Submission for Job: #6010 SSD 6010 - One Residential Building (Student Accommodation) within Darling Drive Plot

Site: #2824 SICEEP Site, The Haymarket; Darling Drive, Sydney

**SSD 6010 - One Residential Building (Student Accommodation) within Darling Drive Plot**

**2 August 2013**

SHADOW DIAGRAMS: PERSPECTIVE, SHOWING THE PEAK, WINTER SOLSTICE

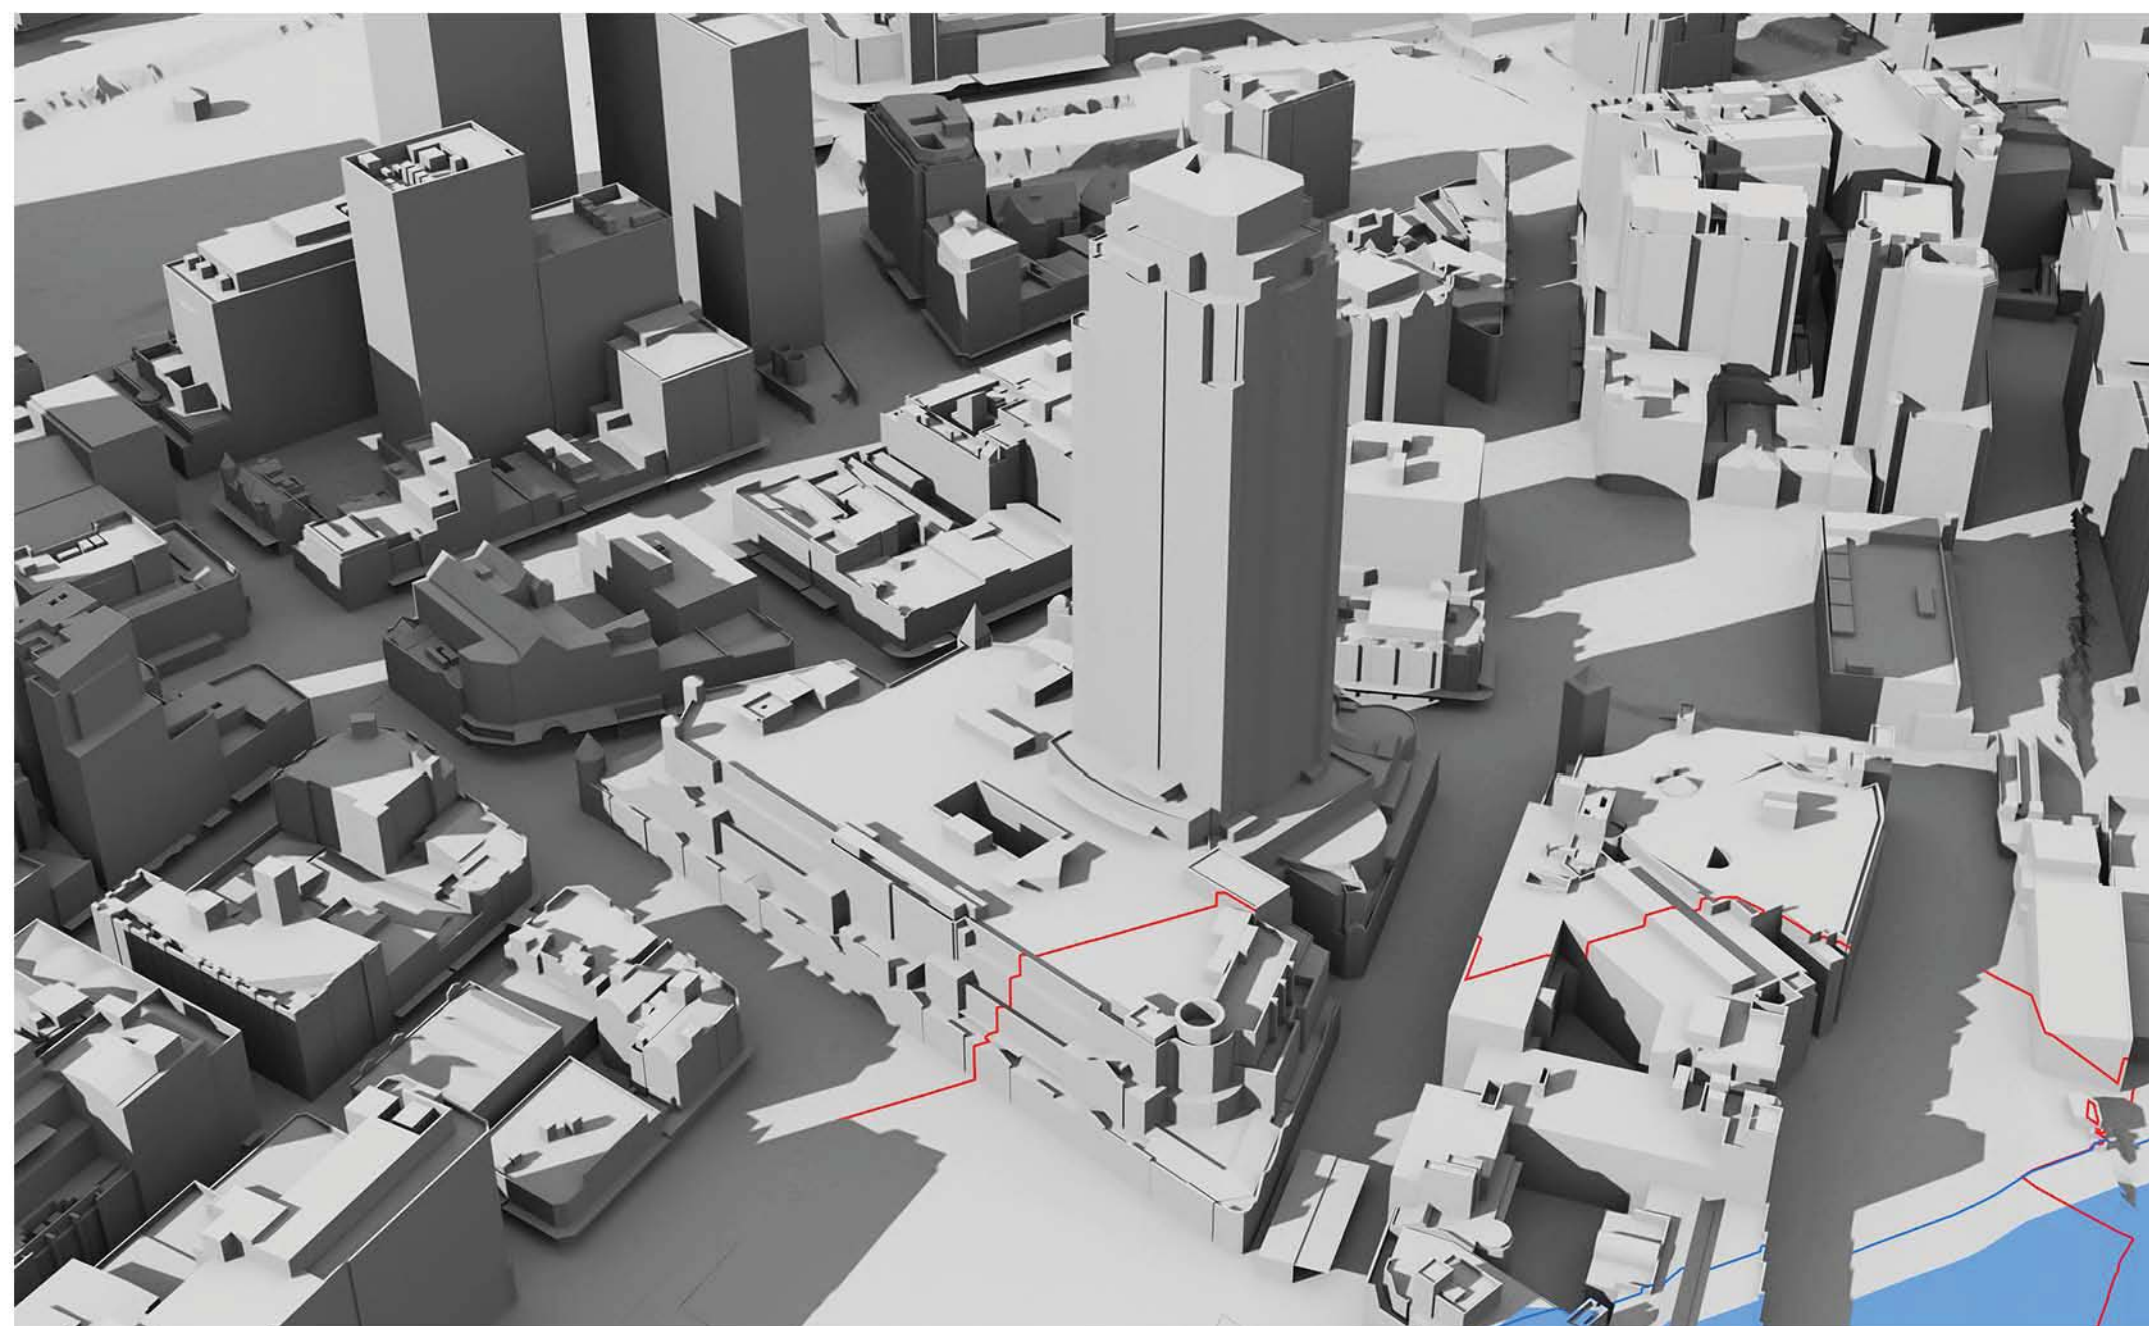
At 9am, 10am and 11am the west façade is totally in shadow due to other parts of The Peak building itself.

At 12pm there is still substantial existing shadowing on the west façade caused by the irregular shape of the west facade.

At 1pm the existing shadowing has been substantially removed, but not totally removed.

It can be concluded that some single aspect apartments on the west façade and some south-west dual aspect corner apartments currently receive less than 2 hours direct sunlight to habitable rooms and 50% of the private open space between 9am and 3pm on 21 June.

At 9am, 10am and 11am the west façade is totally in shadow due to other parts of The Peak building itself.

At 12pm there is still substantial existing shadowing on the west façade caused by the irregular shape of the west facade.

At 1pm the existing shadowing has been substantially, although not entirely, removed. However, overshadowing of lower levels of the west façade by the concept proposal parameter plan shadows for the N,NE and SE plots has already started.

By 2pm the existing shadowing has been totally removed. However, overshadowing of the west façade by the SSDA4 and SSDA5 buildings has appeared and risen further up the west façade than the concept proposal parameter plan shadows for the N,NE and SE plots, which is still present.

At 3pm, the proponent states correctly that 45-45% of the western façade is overshadowed by the SSDA4 and SSDA5 buildings.

It can be concluded that, as a result of combination of the proposed development with existing shadowing of the west façade, some single aspect apartments on the west façade and the south-west dual aspect corner apartments which currently receive less than 2 hours direct sunlight to habitable rooms and 50% of the private open space between 9am and 3pm on 21 June will suffer additional overshadowing. It is beyond our skills to count the number of such apartments. We note that the proponent has made no attempt to do so.
